Rezoning Petition Review

Date of Review: January 17, 2020 (*Revised February 14, 2020*)

Rezoning Petition #: 19-179

Location of Property: Approximately 1.0 acres located on the south side of Parkwood Ave and east of Hawthorne Ln.

RZ-1.0

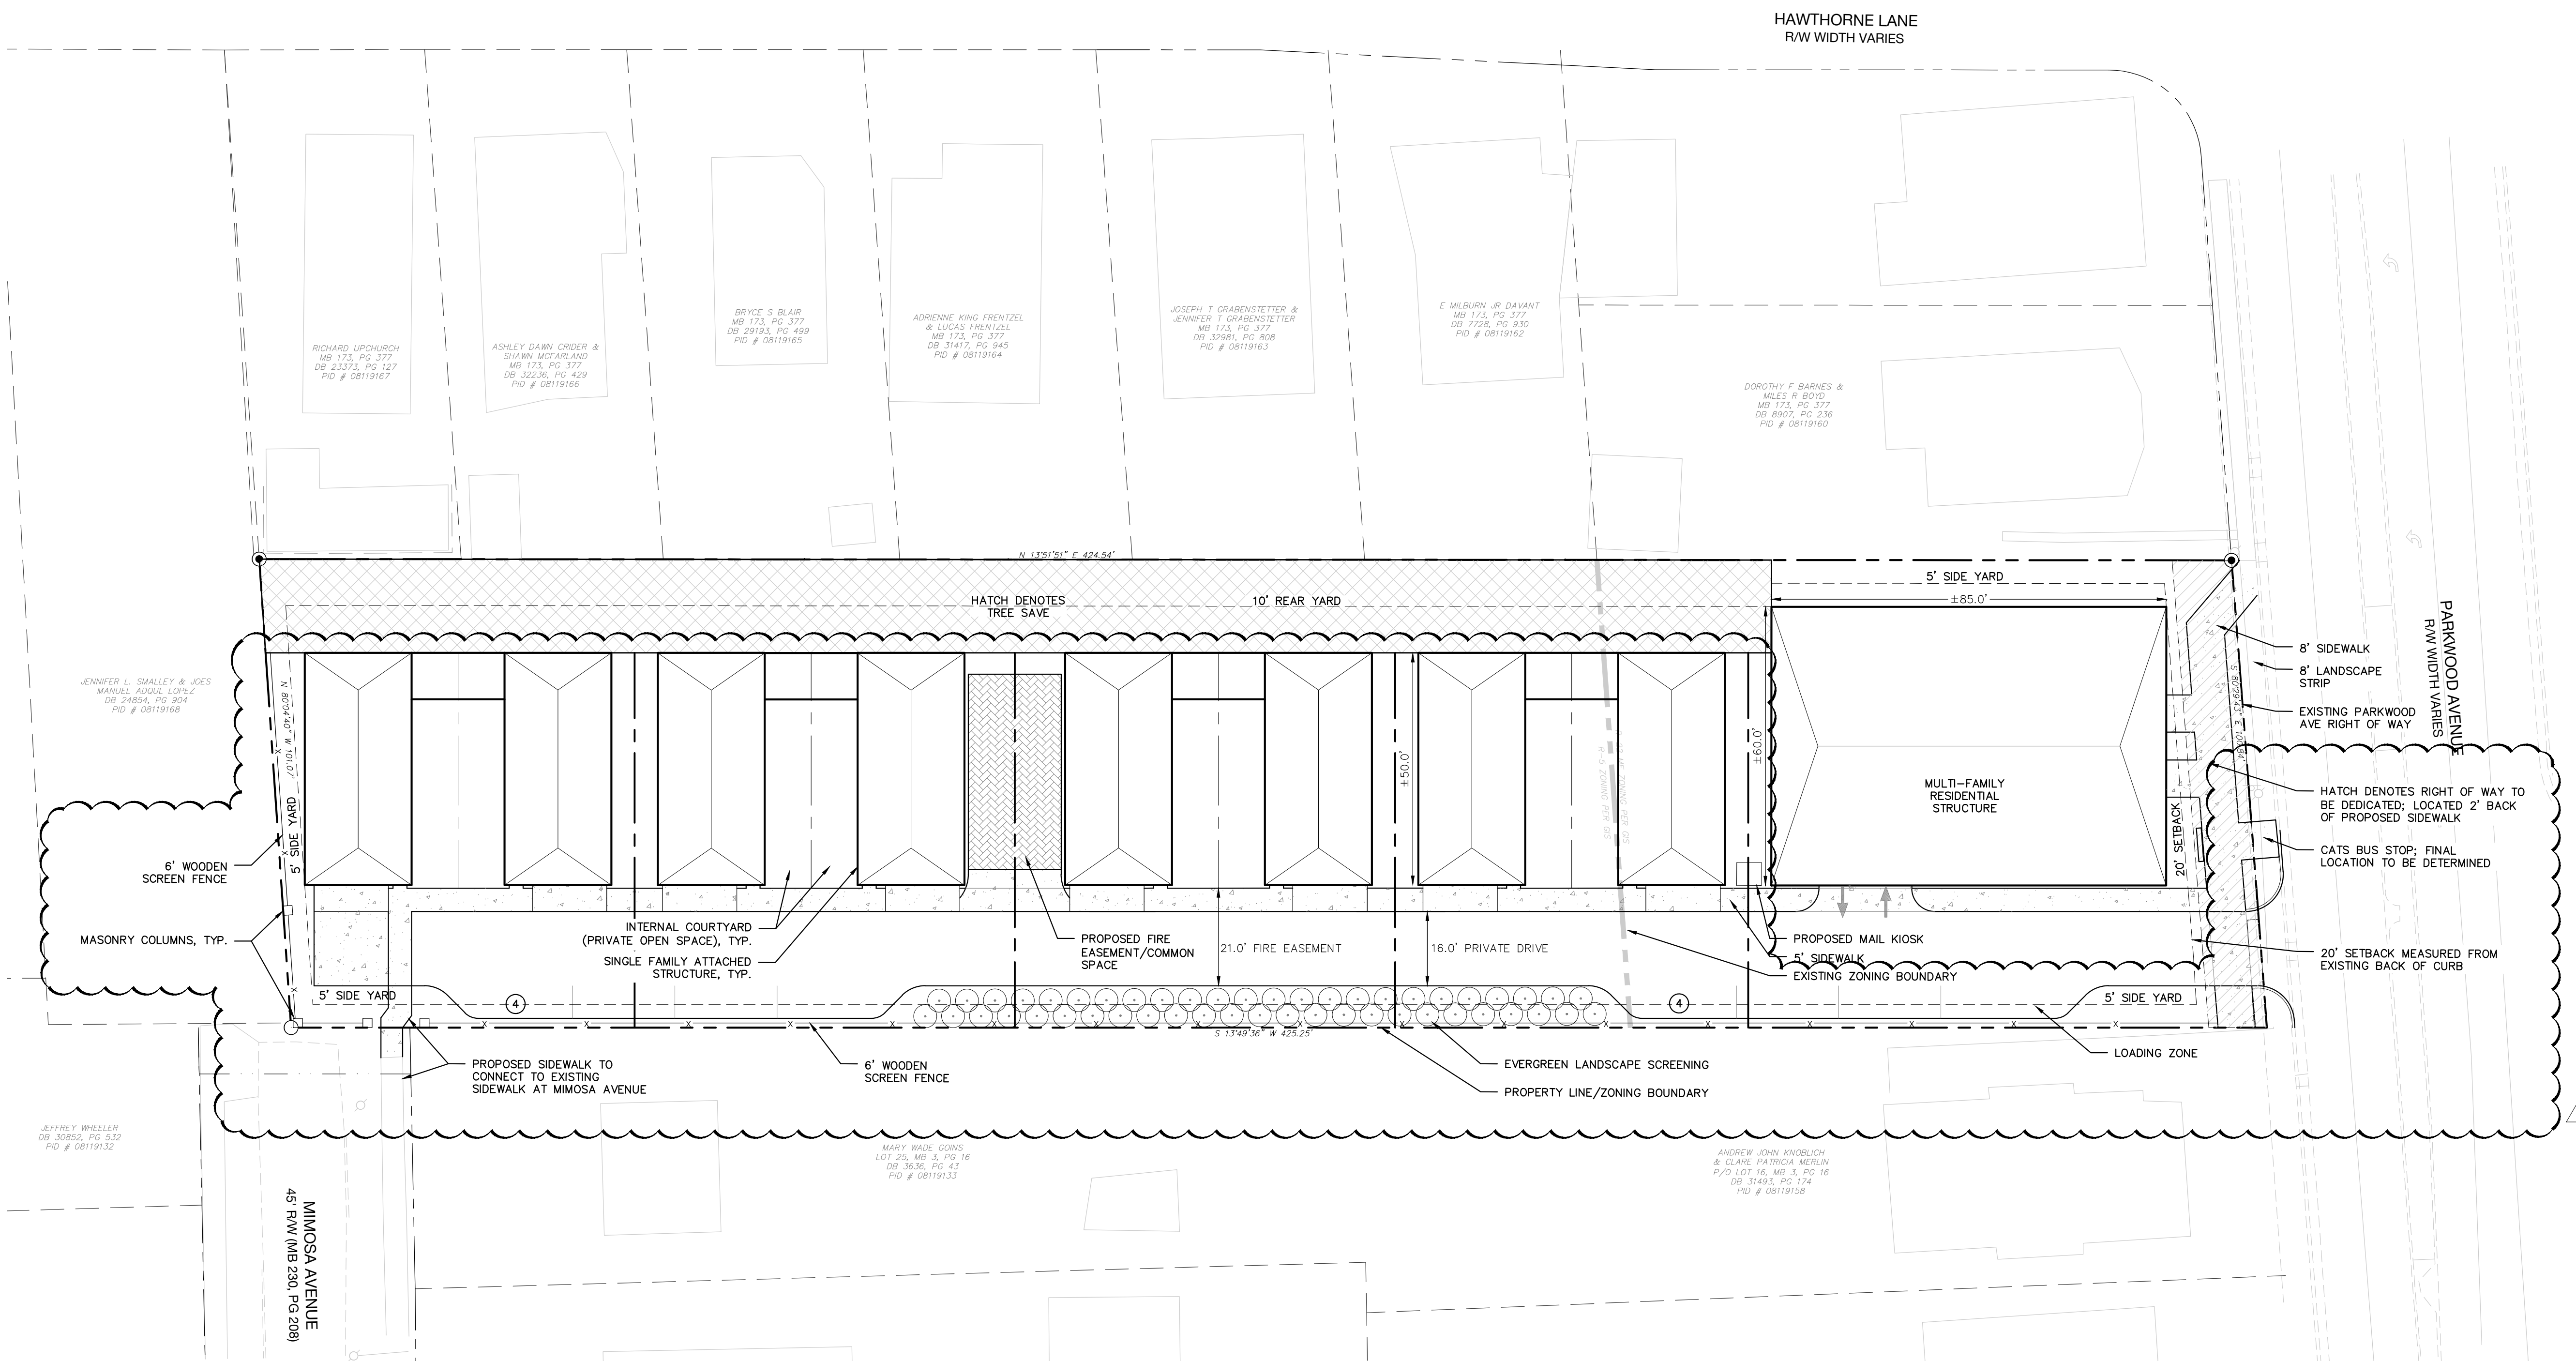
Recommendations Concerning Storm Water: Please include the following note under Environmental Features. *The petitioner shall analyze the adequacy of the existing storm water conveyance to the nearest public right-of-way. If the existing storm water conveyance is are found to be inadequate, the Petitioner shall make a good faith effort to improve the storm water conveyance or mitigate the storm water discharge.*

Due to revisions (2/14/20): *No additional recommendations are needed at this time.*
